City of Albuquerque
Stormwater Construction Site
Inspection Report

Phil Lindborg, Boyhan LLC: phillindborg@comcast.net
Alameda and Louisiana Commercial Development

Re: Drainage Ordinance (14-5-2-1) Violation for Erosion and Sediment Control

Legend	
---	Erosion Sediment Control Plan
---	Staging Area
---	Stabilized Construction Entrance
---	Silt Fence
---	Block Wall
●	Chemical Toilet
Ⓢ	Posting Sign

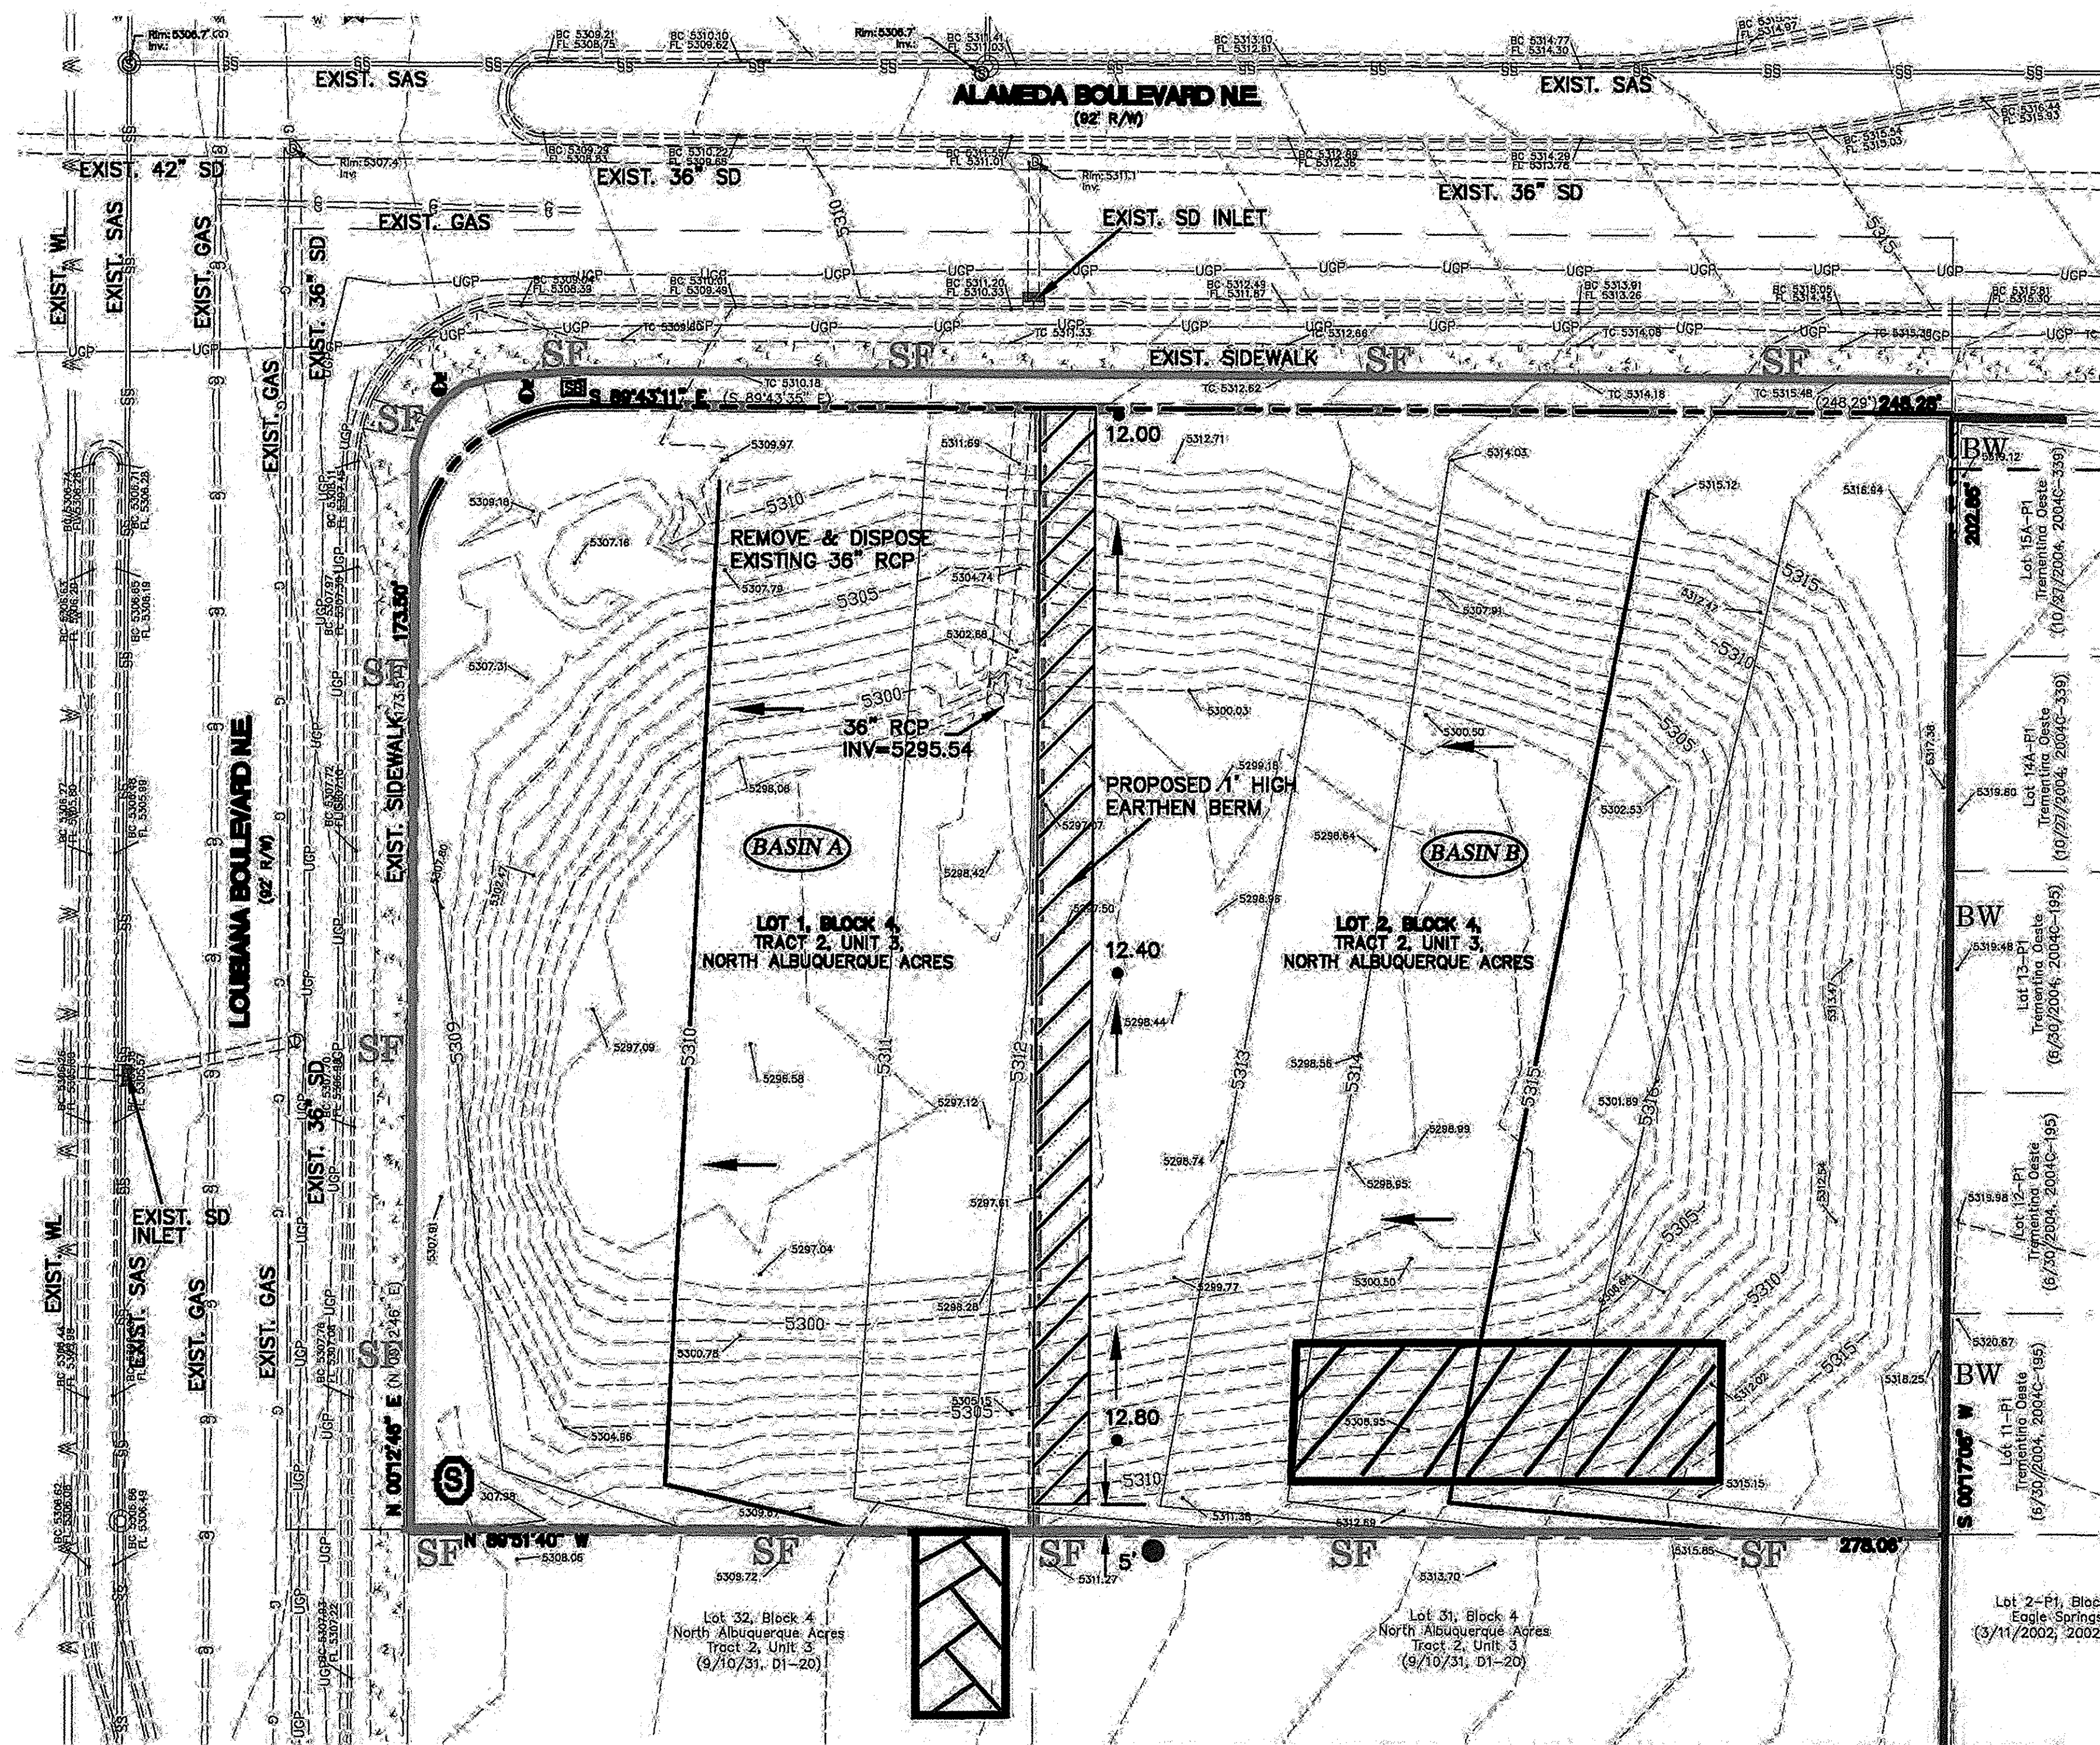
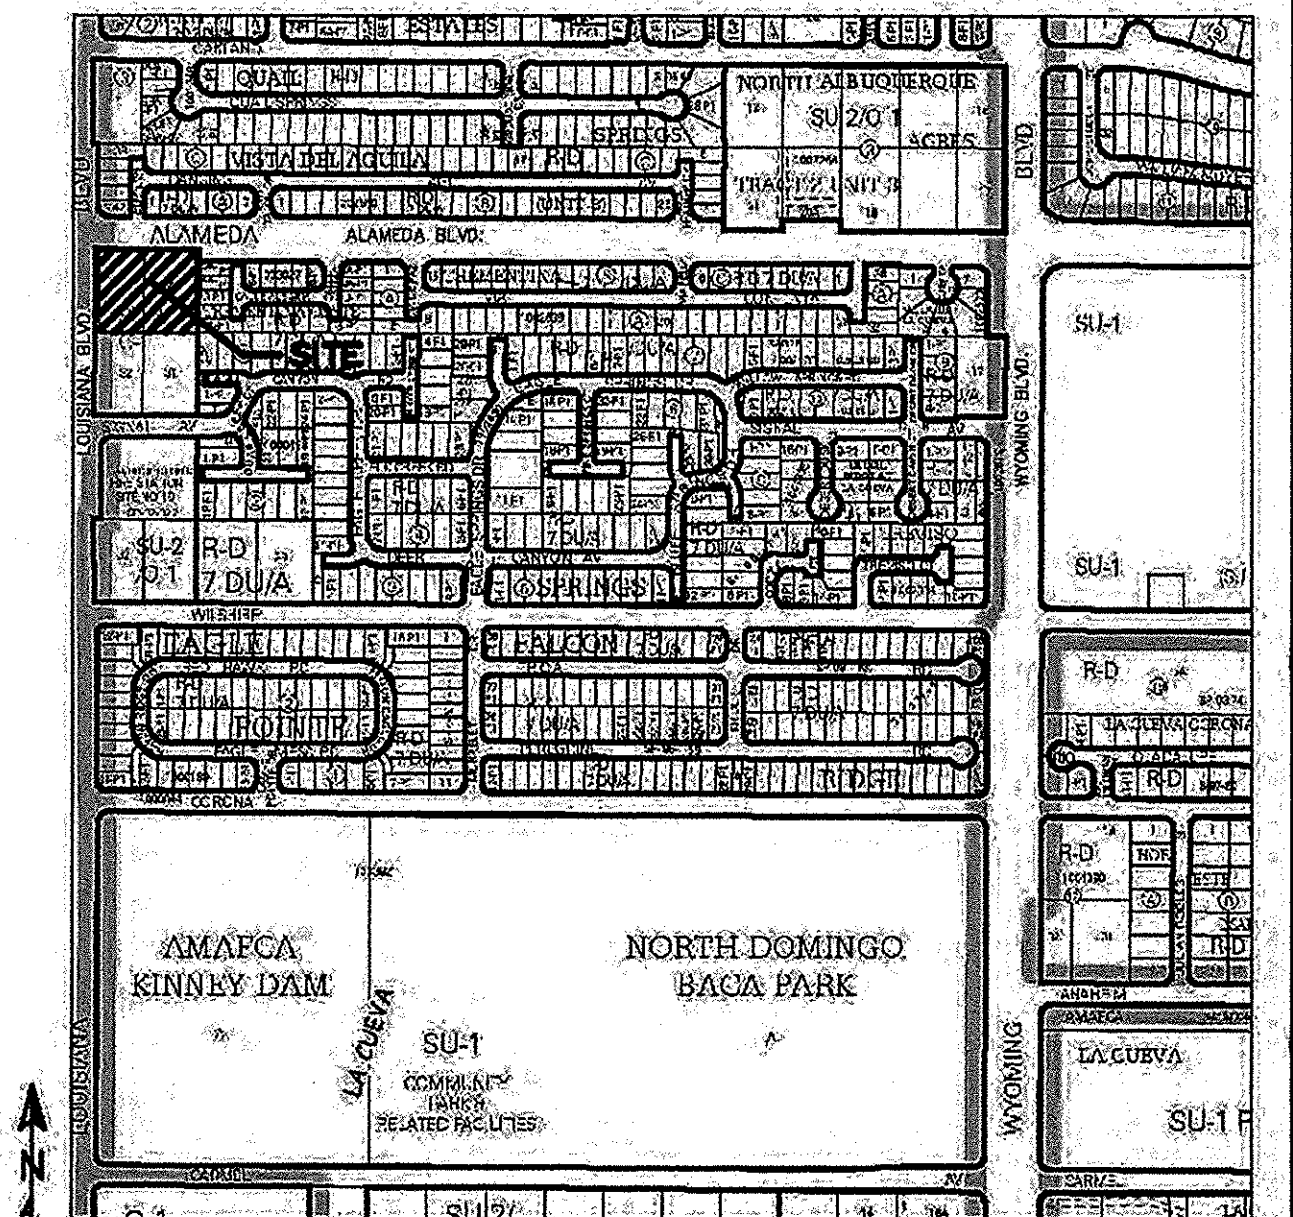
1. Major track-out onto Signal Avenue, Louisiana Blvd and Alameda Blvds.
2. There was no track-out pad and vehicles were leaving through the lot to the south. The approved Erosion and Sediment Control Plan shows the track-out pad on Louisiana.
3. Gap in the silt fence at the northeast corner.

1. Remove sediment from street and gutter pan on Signal Ave, Louisiana Blvd and Alameda Blvd from Louisiana to Via de Paz St.
2. Install the track-out pad per approved ESC plan.
3. Replace silt fence in Northeast corner.
